Determination of Thomas Street Car Park Site Modification 6

The above modification application lodged by Meriton Property Services Pty Ltd (the proponent) has been referred to the Planning Assessment Commission (the Commission) for determination under Ministerial delegation dated 14 September 2011. The delegation is authorised because more than 25 submissions in the nature of objections were received.

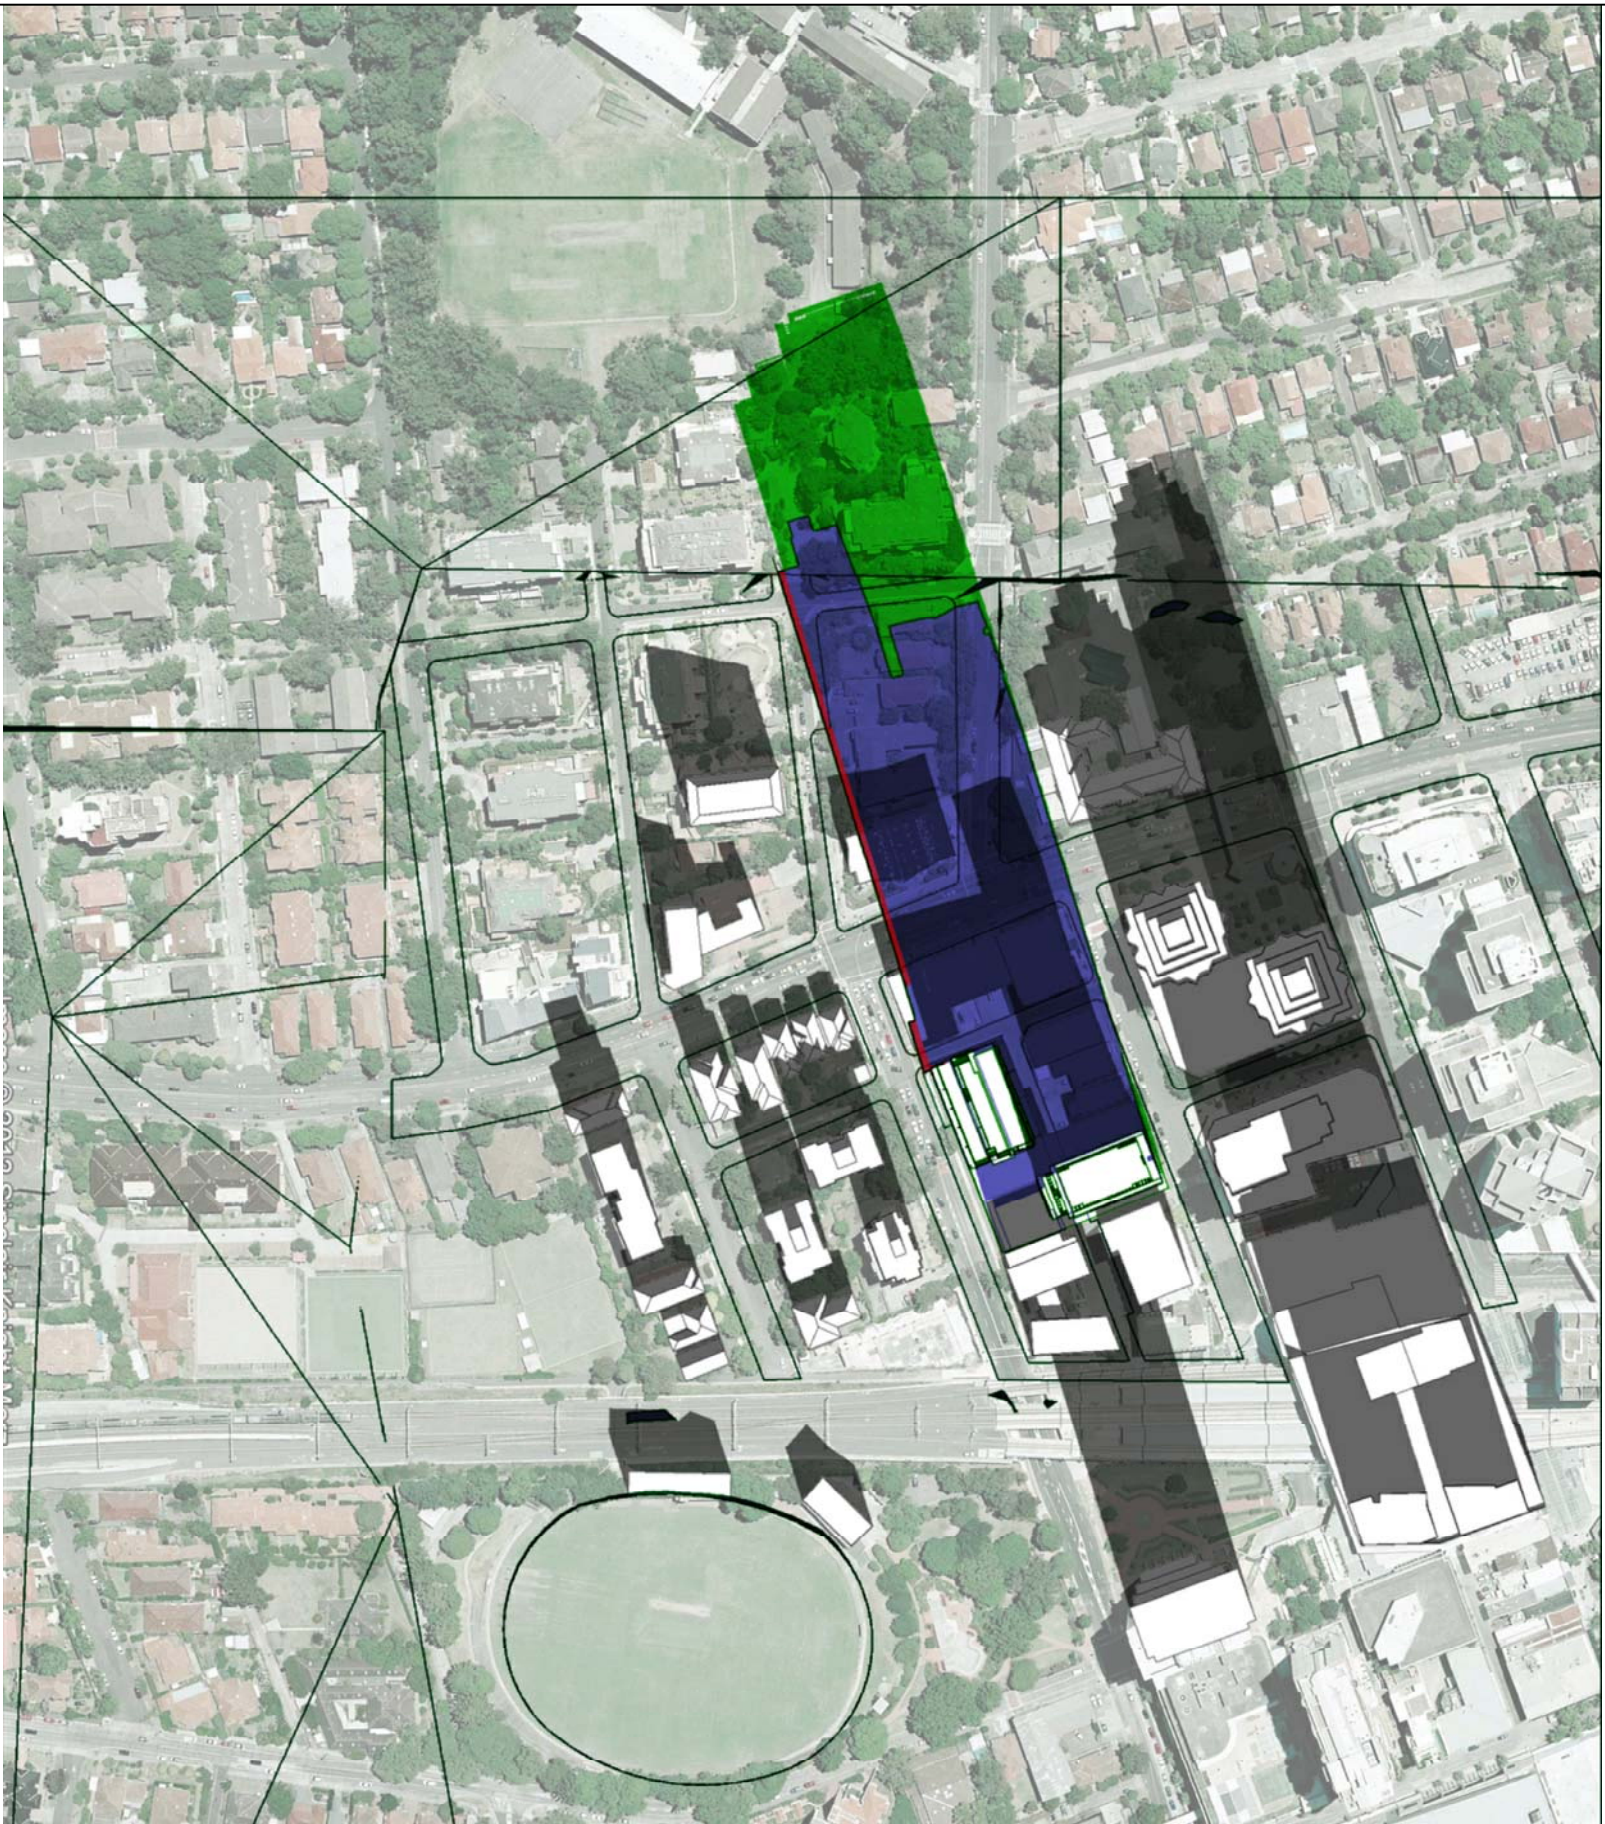
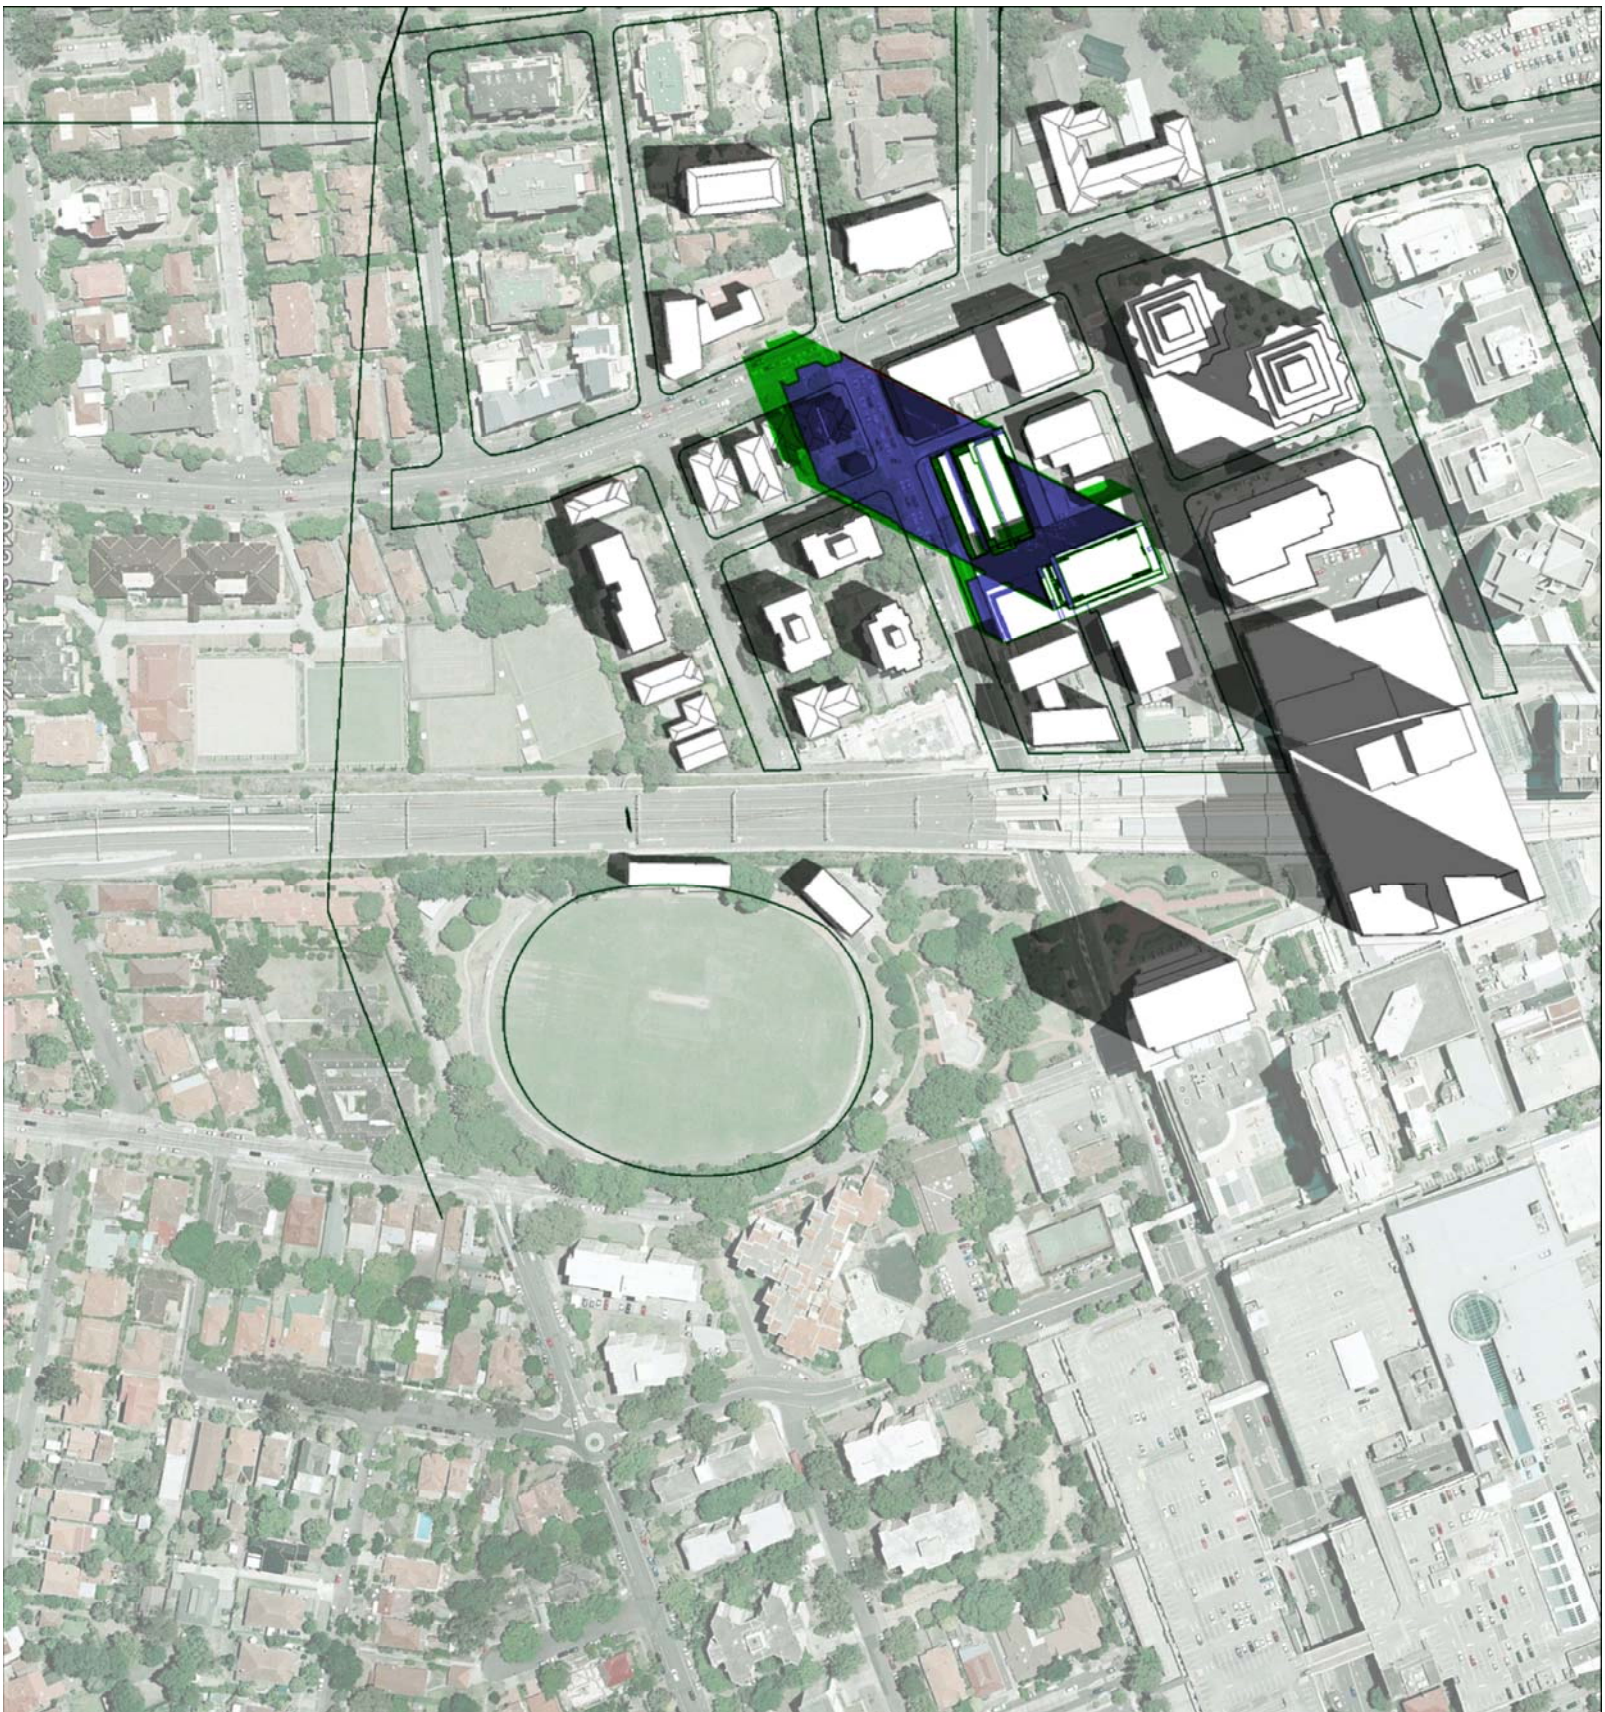
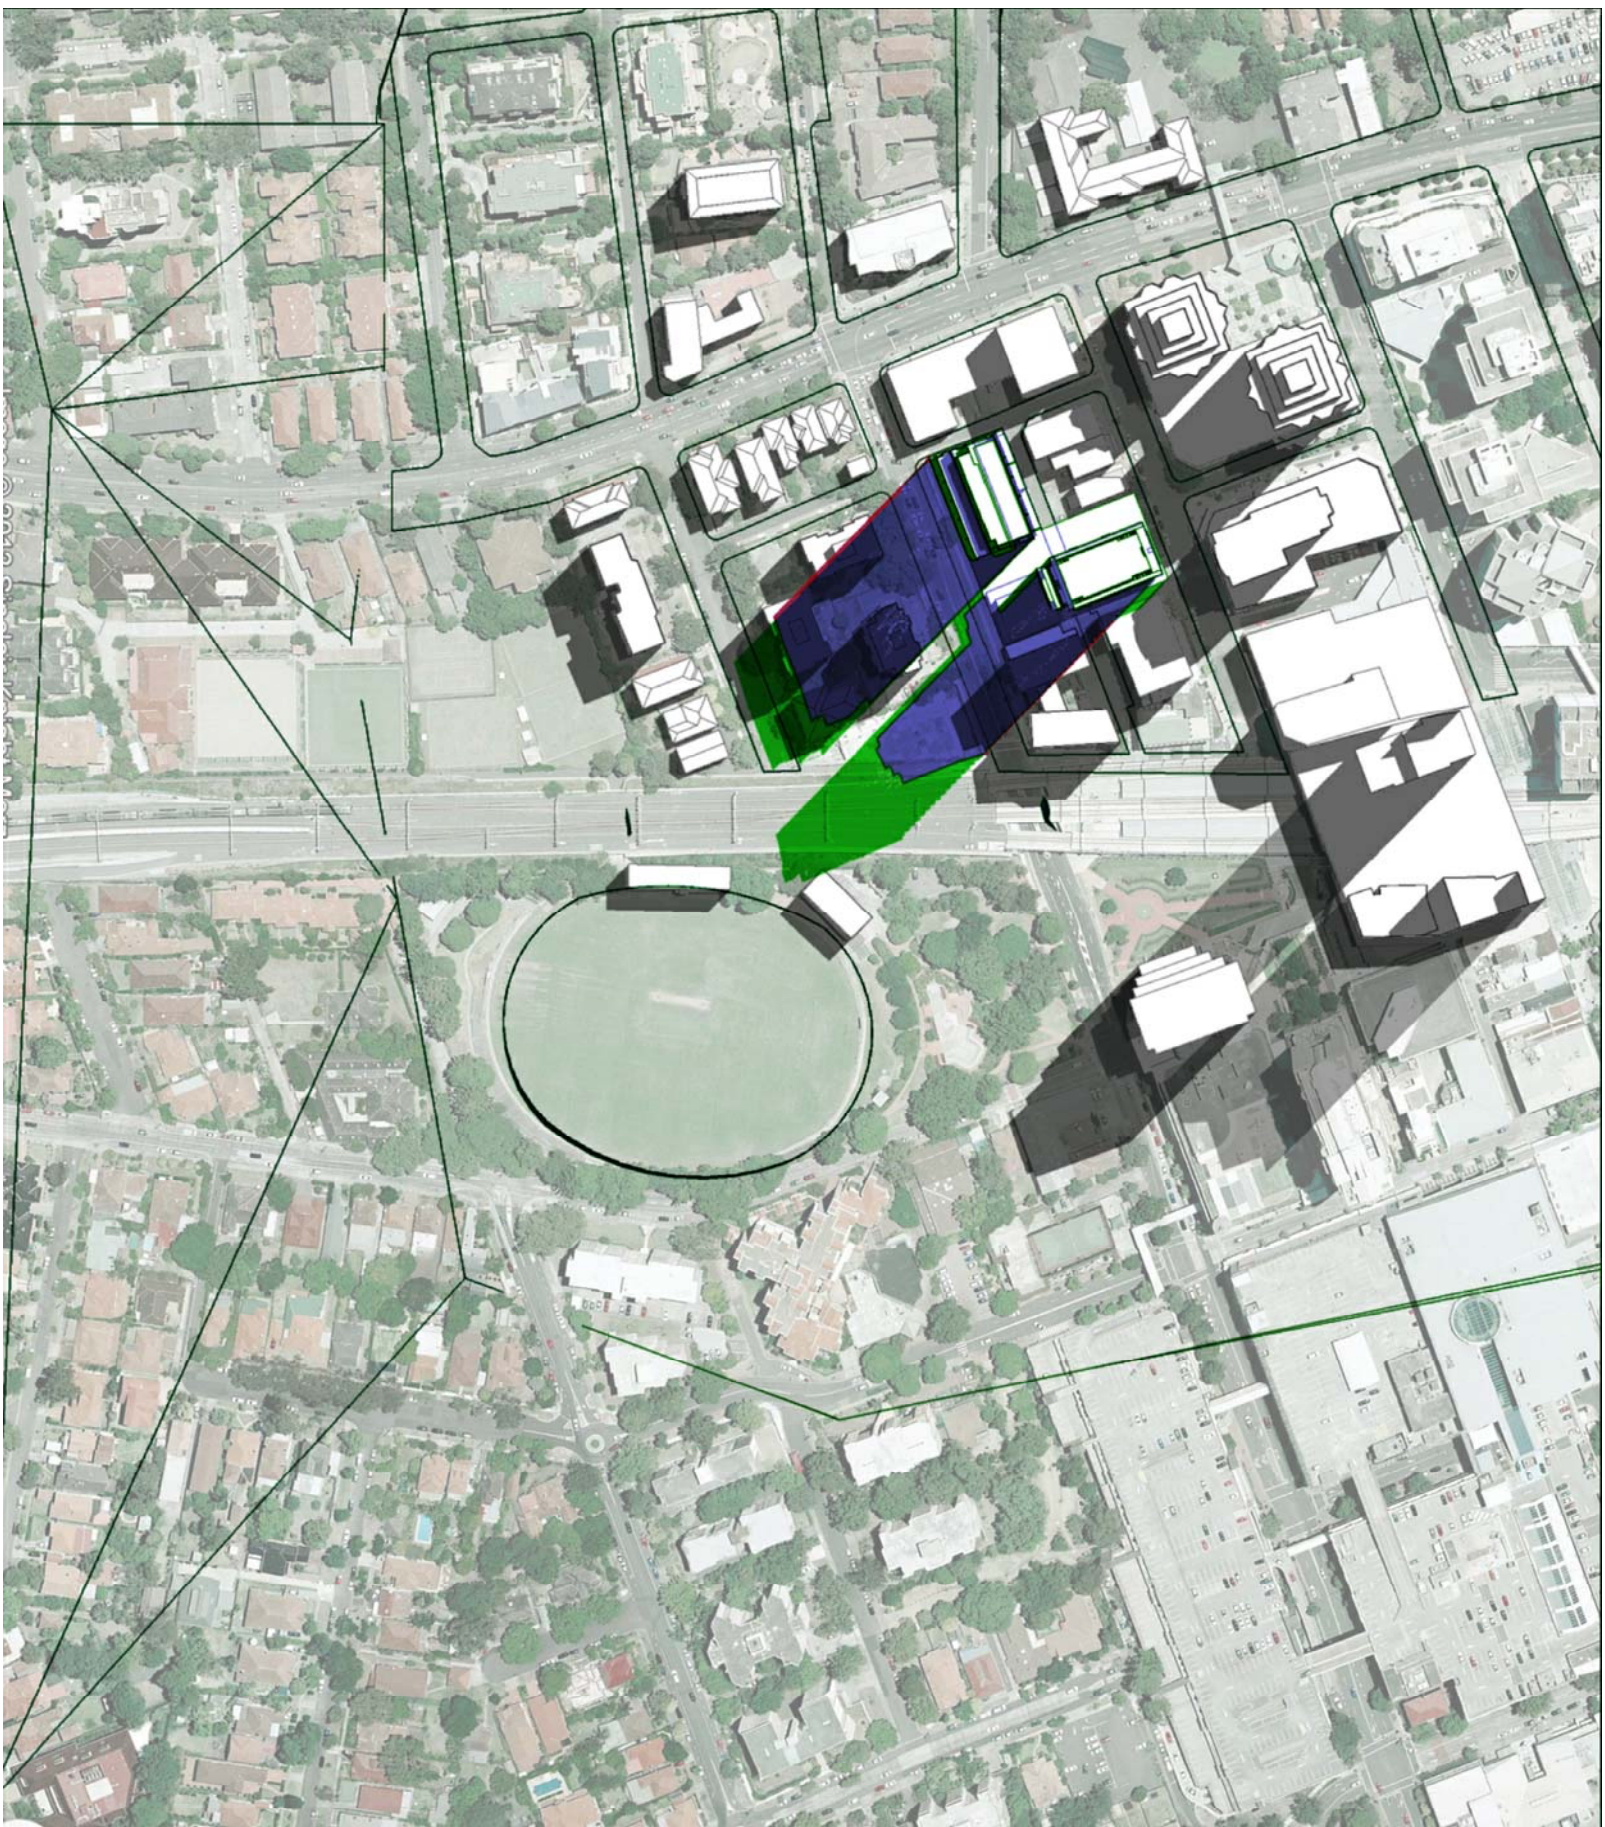
The Commission closely reviewed the shadow diagrams submitted by the proponent and found inconsistencies. It requested additional detailed shadow diagrams (weekly diagrams on hourly base between 31 March to 30 June) to clarify the extent of the impacts (between April and September) and these were supplied by the proponent on 19 September 2013.

The shadow diagrams show that there are already shadows being cast over the Oval by the approved development and other existing buildings. They also show the impact of this application (Mod 6) during the period from around 7 April to around 23 September, commencing at approximately 2.15pm. During this period, there are new shadows cast over the oval in locations that were previously sunlit.

These new shadows are essentially removing much of the limited sunlight that does reach the oval in the afternoon and would make the oval mostly shaded. The Commission considers this to be a very negative outcome, and is of view that just because the oval receives relatively good morning exposure in the period, this does not offset the negative impact in the afternoons.

A wider residential area will be subjected to new overshadowing as a result of the proposed increase in height of the towers. This occurs both during the mornings and afternoons, and is greatest in the months from April to September. The Commission agrees with the Department that these new shadows are moving quite quickly over the properties that are impacted.

The assessment report concludes that the impact of the overshadowing can be mitigated by a reduction of 5 storeys to the residential tower. The Commission has reviewed the result of such a reduction in height and does not consider the overshadowing outcome is adequately mitigated. The recommended height reduction would only reduce the impact to a minor extent. The Commission notes that Council expressed a similar view at the public meeting.
